SECTION 4.55(1A) MODIFICATION APPLICATION STAGE 1B BASEMENT – ONE SYDNEY HARBOUR, BARANGAROO SOUTH

This modification application has been prepared by Ethos Urban on behalf of Lendlease (Millers Point) Pty Ltd, pursuant to section 4.55(1A) of the *Environmental Planning and Assessment Act 1979* (EP&A Act) to modify Development Consent SSD 6960 relating to the Stage 1B Basement at One Sydney Harbour, Barangaroo South (the site).

BB2 _PA2_A000	F	TITLE SHEET
BB2 _PA2_A100	E	BASEMENT PLAN LEVEL B0
BB2 _PA2_A101	F	BASEMENT PLAN LEVEL B1
BB2 _PA2_A102	D	BASEMENT PLAN LEVEL B2
BB2 _PA2_A103	D	BASEMENT PLAN LEVEL B3
BB2 _PA2_A104	D	BASEMENT PLAN LEVEL B4

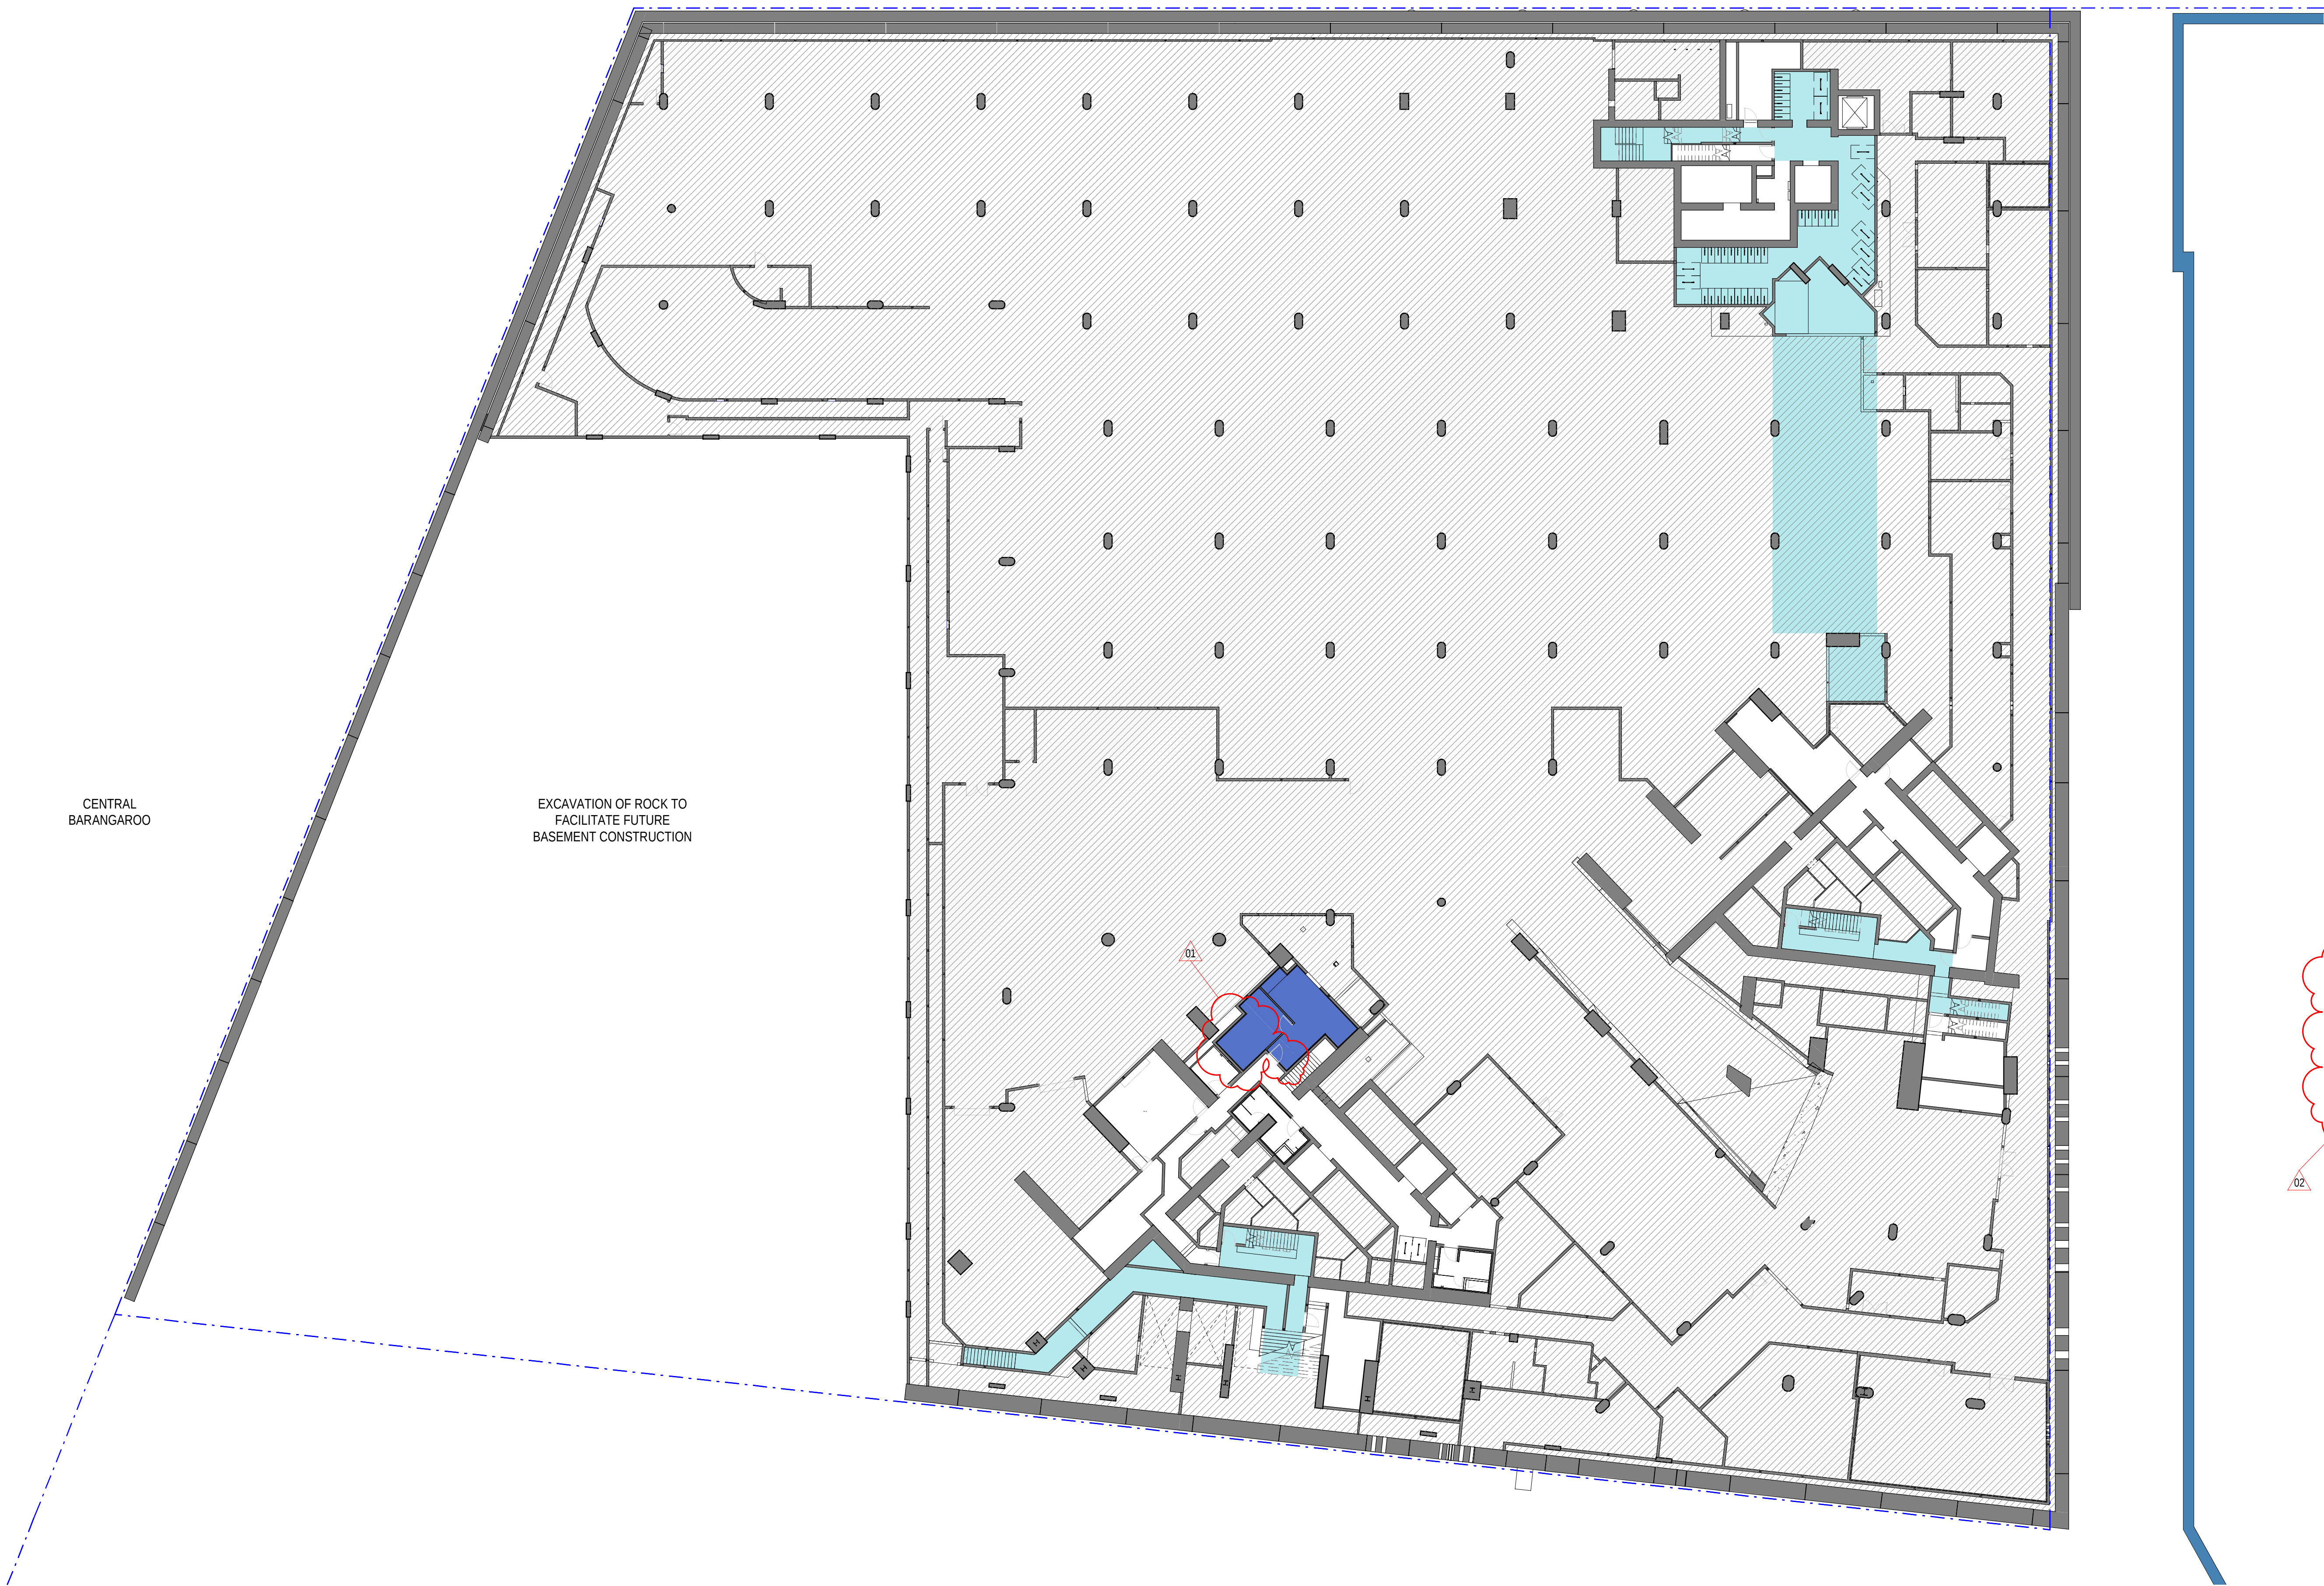
As shown at **Figure 1**, previously residential GFA (shown in yellow) is proposed to be reallocated as non-residential other uses GFA (shown in purple). A similar reallocation also occurs on Basement Level B1.

Figure 1 Proposed GFA reallocation on Basement Level B0
